**Consultation Response from Mike Hibbert,
KC Waste Strategy(Refuse & Recycling)**

2023/92448 Former Cooper Bridge Water Treatment Works, Leeds Road, Huddersfield, WF14 0BT

Outline application for erection of B8 industrial unit

Responding Ref: WPN 23-047

Number
2001

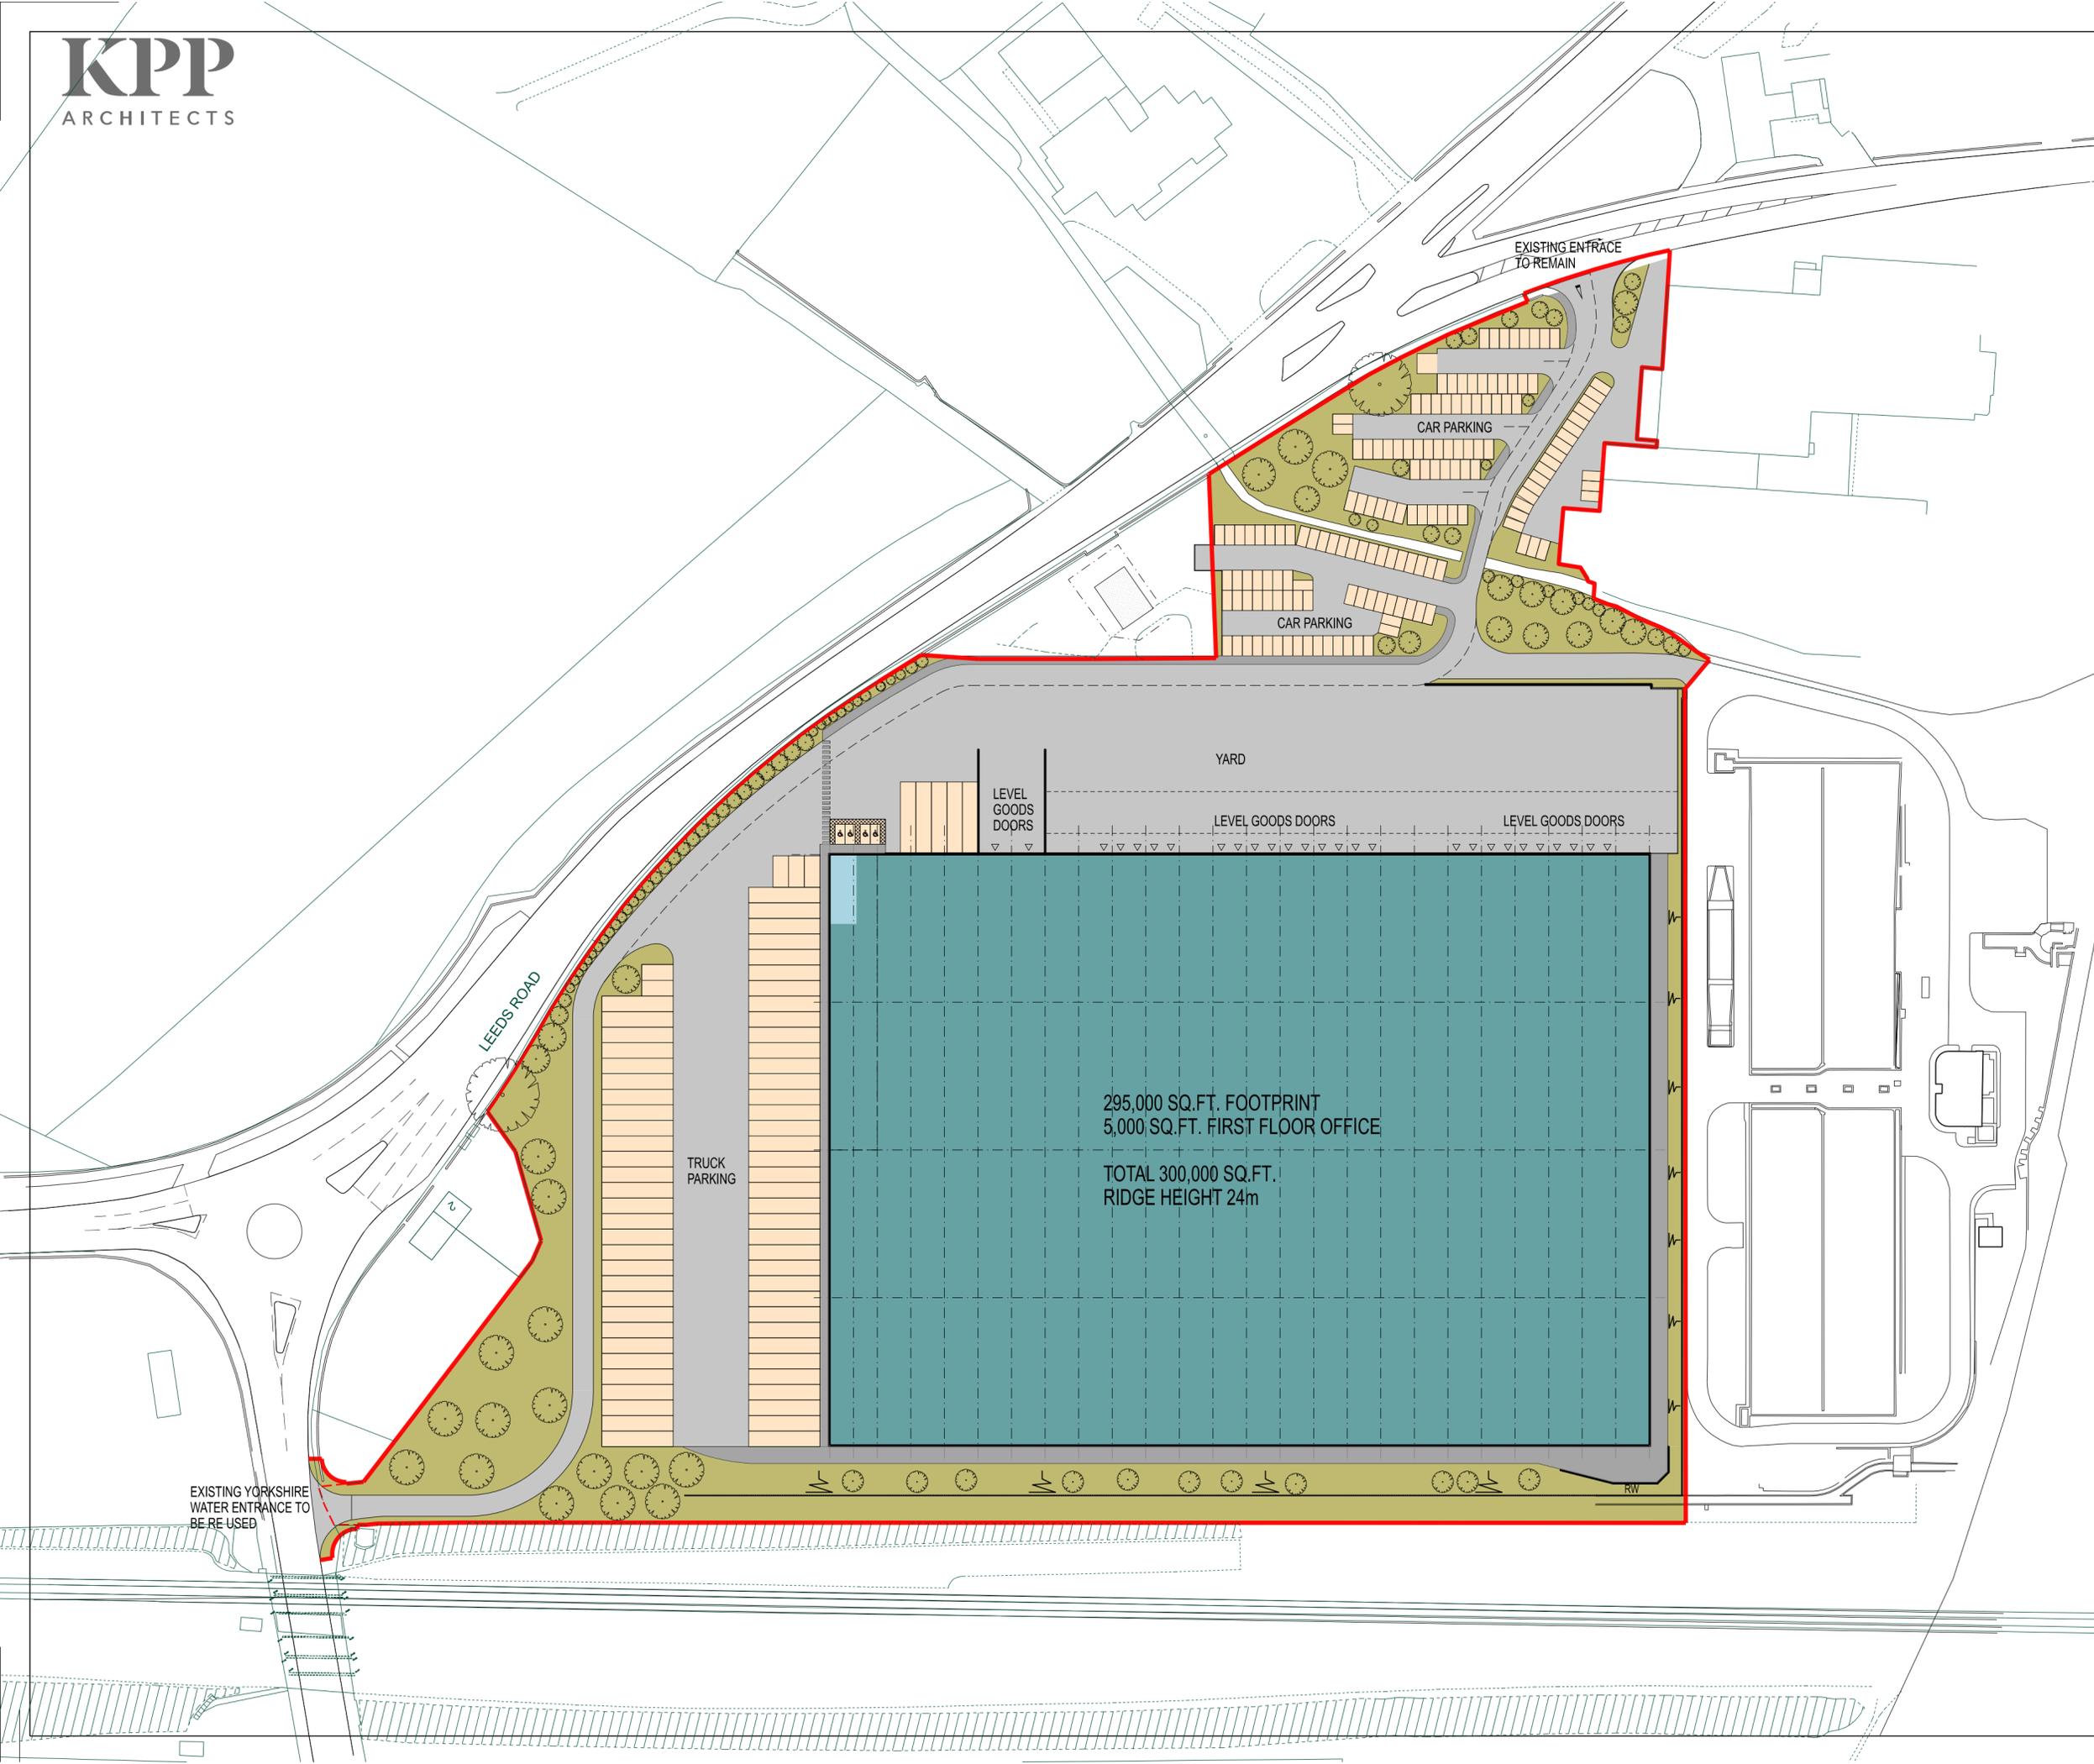
- The application form does not include any details on waste storage within the proposed development and no locations for waste storage are identified on Site Plan No2001 dated June 2023.
- With limited information included in the application it is difficult to predict likely waste generation and therefore waste storage capacity required. As the applicant has two existing warehouses in Ravensthorpe and Bradford in addition to the manufacturing site next to the proposed development waste arisings data should be available and there will be existing provision for waste generated at those sites. Any waste storage area should be secure to prevent theft, unauthorised use/ fly tipping, arson or rough sleeping.

- In line with Government's OUR WASTE, OUR RESOURCES: A STRATEGY FOR ENGLAND and the requirement for waste producers to comply with Regulation 12 of The Waste (England and Wales) Regulations 2011 there should be separate provision for recyclates and residual wastes. Waste storage should be identified on site either within the warehouse or on the service yard to accommodate general waste and packaging/ cardboard skips, etc.
